SECTION 131 FORM

Appeal NO: ~~ASP~~ ABC-322154-25Defer Re O/H ☐Having considered the contents of the submission dated/ received 24/11/25
fromThe Responsible Energy recommend that section 131 of the Planning and Development Act, 2000
be not invoked at this stage for the following reason(s): No new planning issuesE.O.: Daniel O ConnorDate: 25/11/25

Kilmanagh Ballycallan Tullaroan (KBT)

An Bord Pleanála Planning Reference	ABP-322154-25
KCC Planning File	256003
Name	Briskalagh Ltd.
Address	In the townlands of Acragar, Ballyconra, Ballycuddihy, Ballyroe, Ballyroe (Grace), Ballyroe (Maher), Baunaniska, Boherkyle, Briskalagh, Brittas, Clone, Coolnapisha, Curraghduff, Freshford, Freshford Lots, Graigueswood, Grange, Huntstown, Kilmanagh, Knockeenglass, Knockown, Moatpark, Monabrika, Monavadaroe, Moneenaun, Oldtown, Oldtownhill, Parksgrove, Picketstown, Rathealy, Sart, Sweethill, Tobernapeastia, Tullaroan, Upperwood Demesne, Co. Kilkenny.

Figure 35. Flood map with water depths for Design River System and Q_{100cc} design flow.

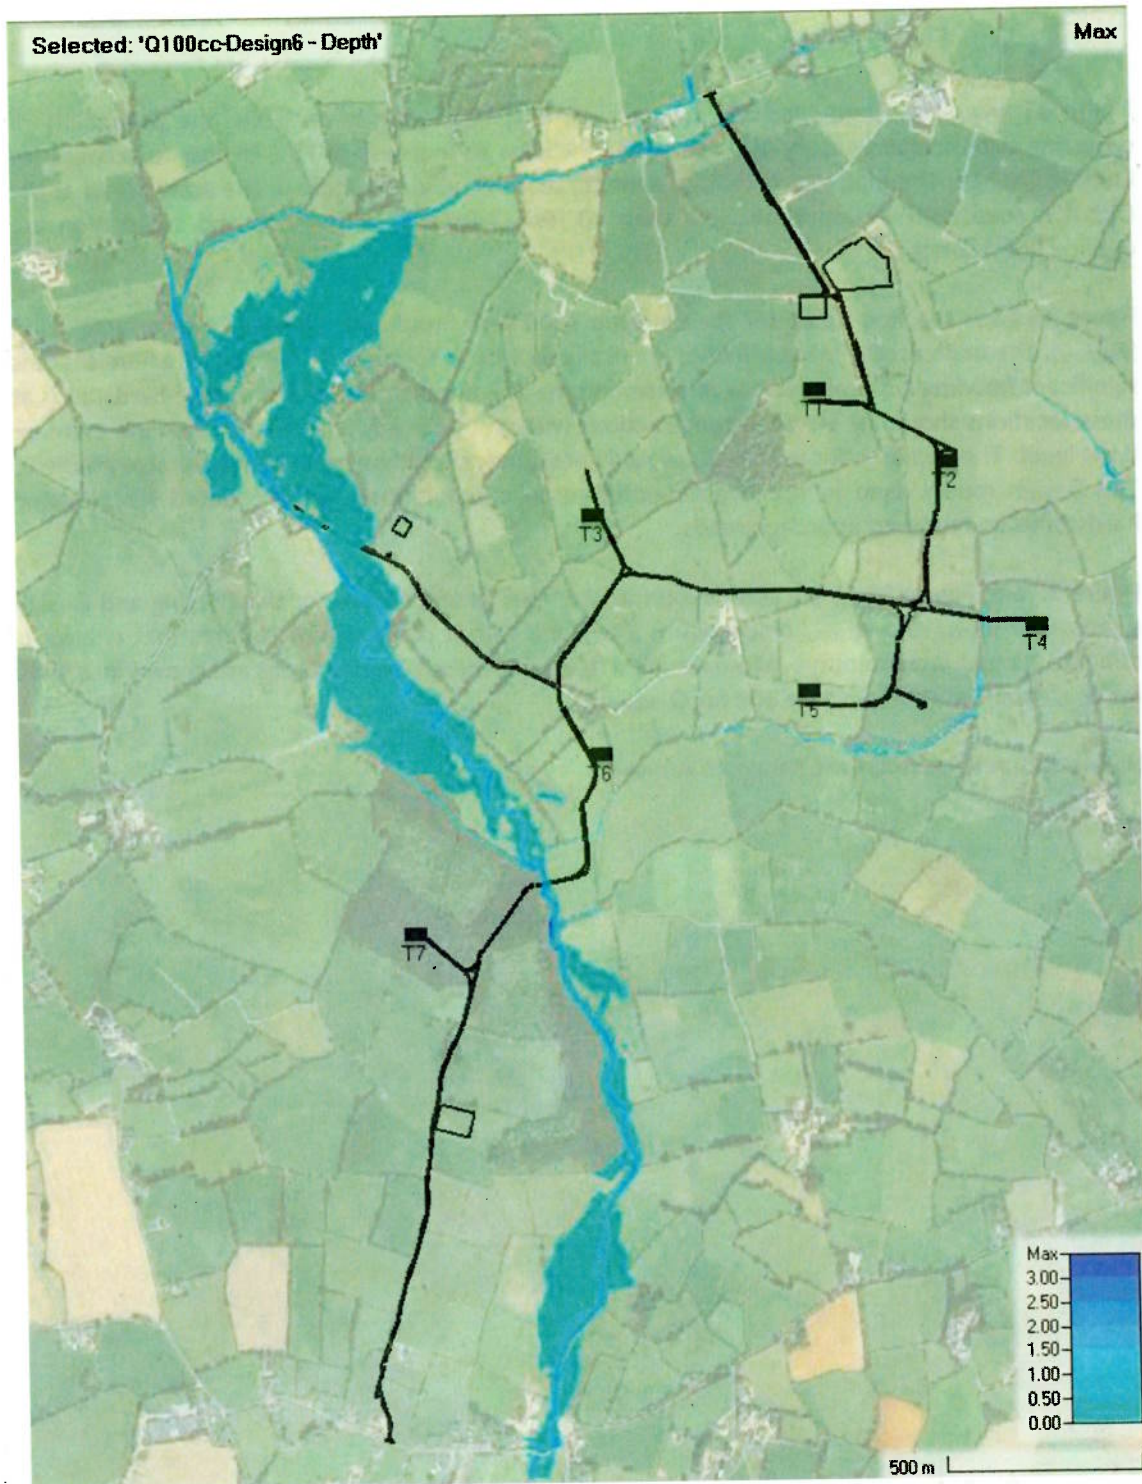
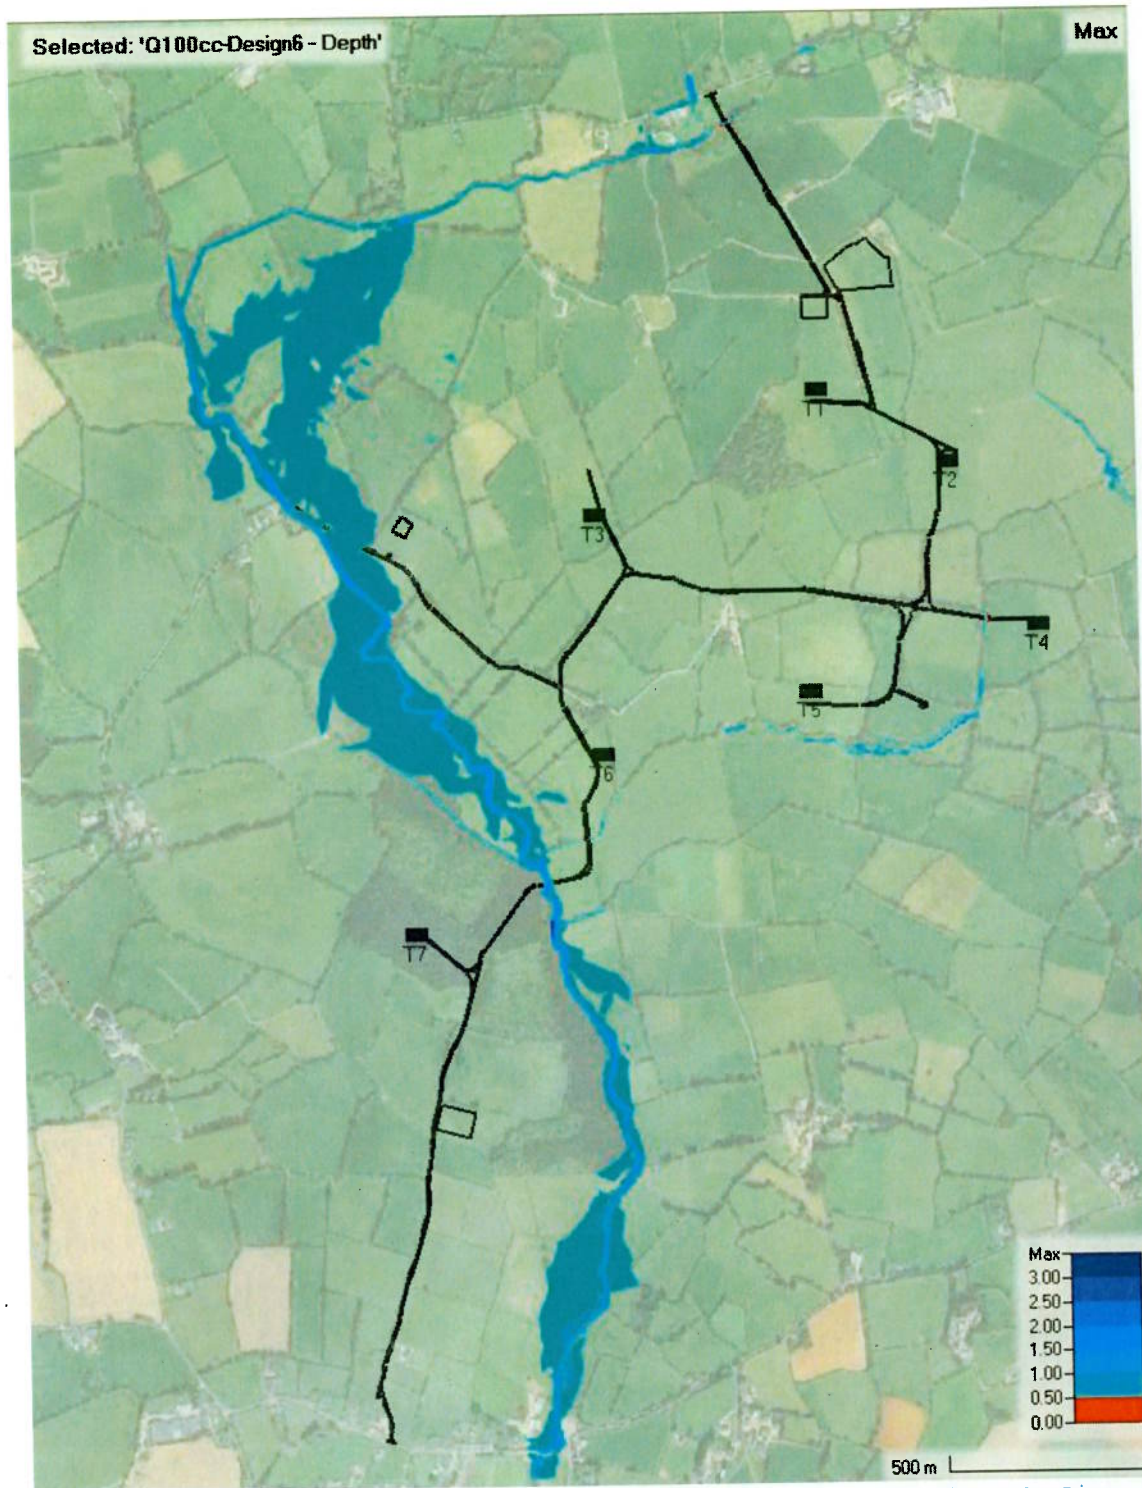
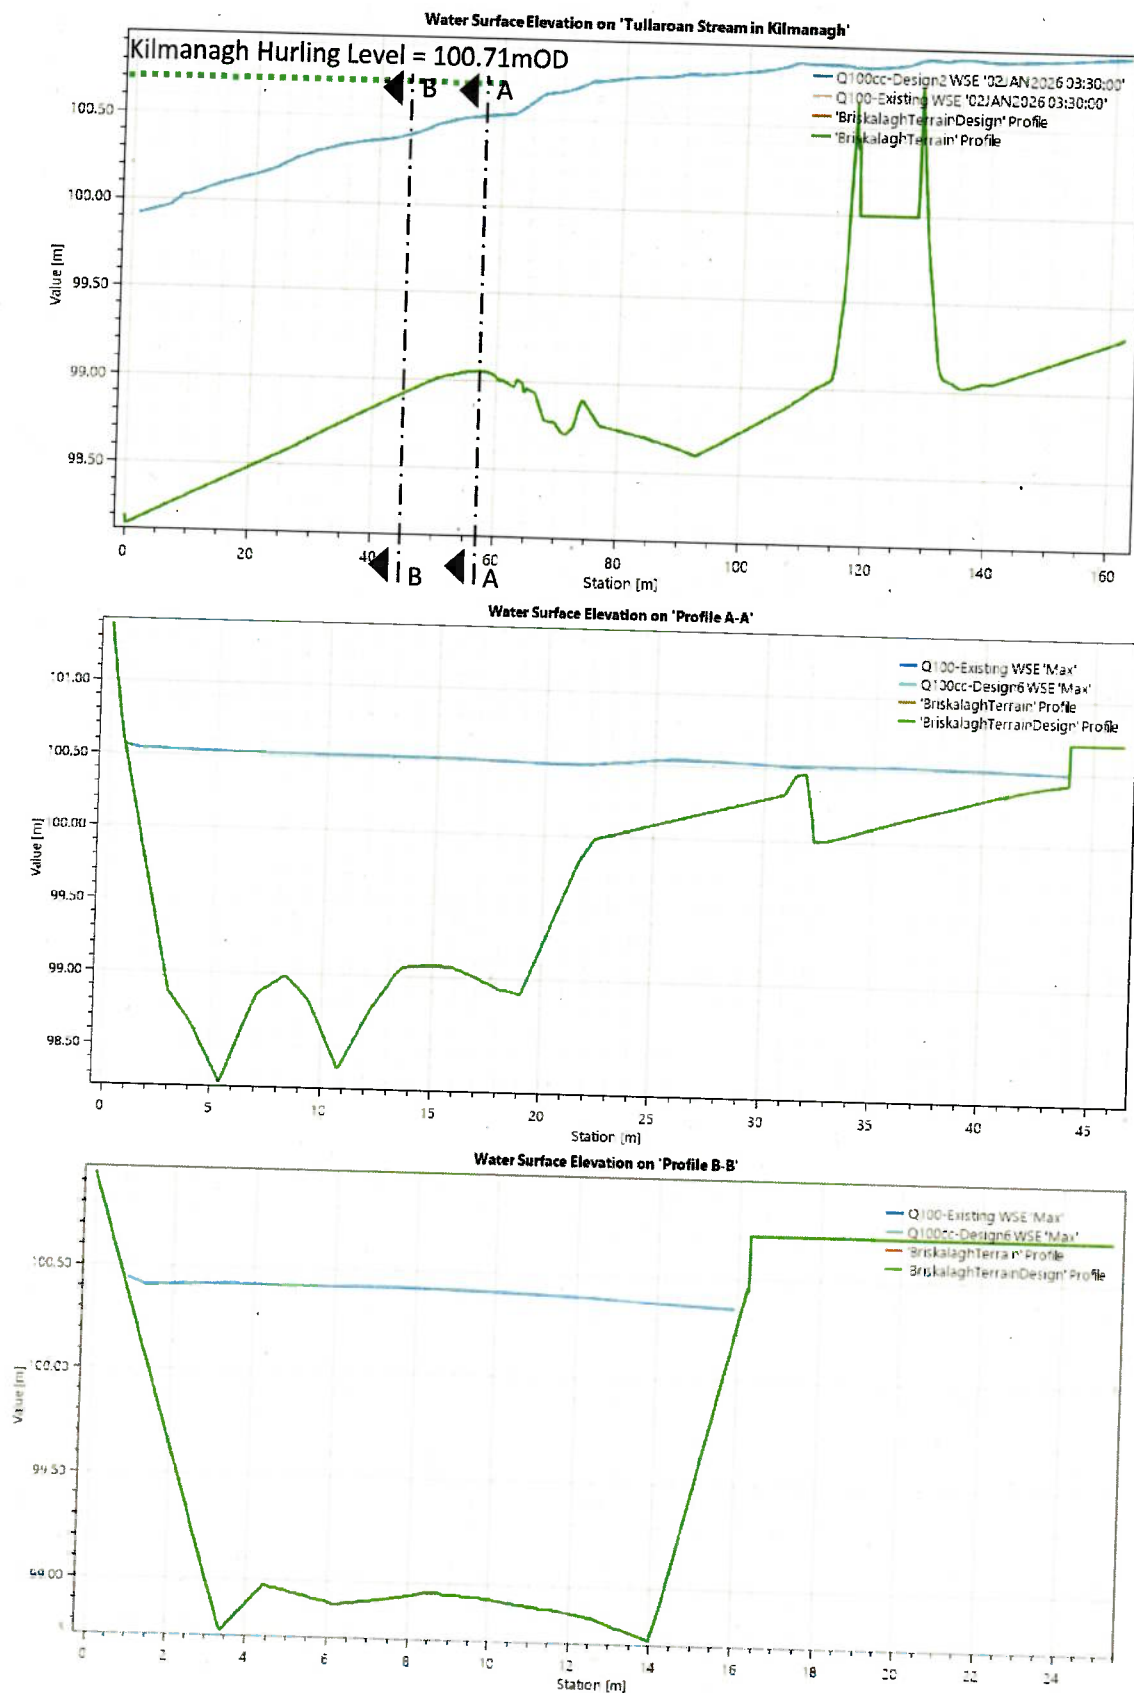
We note the Fluvio R&D Limited report, submitted as part of the appellants Further Information response. Our initial review of this new document finds serious and multiple erroneous statements. One such example can be found on page 50 of the Fluvio R&D Limited report which states that special attention was given to flood levels in Kilmanagh village. In particular, and as highlighted in Figures 33 & 34 of the report, it is explicitly stated that during the occurrence of a Q100cc (1 in 100 year + climate change) or a Q1000cc (1 in 1000 year + climate change) the output of the hydraulic modelling exercise demonstrates that the hurling pitch immediately downstream of Kilmanagh bridge does not flood. **This is a significant and concerning erroneous statement and miscalculation.**

The hurling pitch at this location is known to be subject to flood inundation on a regular basis. Figure 1 below illustrates the hurling pitch following one of three flood events in October and November 2023. And as recently as 11th November 2025, this flooding recurred at this location once again.

This demonstrates that this Site Specific Hydraulic Modelling exercise is significantly flawed and does not provide any confidence whatsoever in relation to the potential adverse impact of the proposed wind farm development on the existing hydrological regime of the area
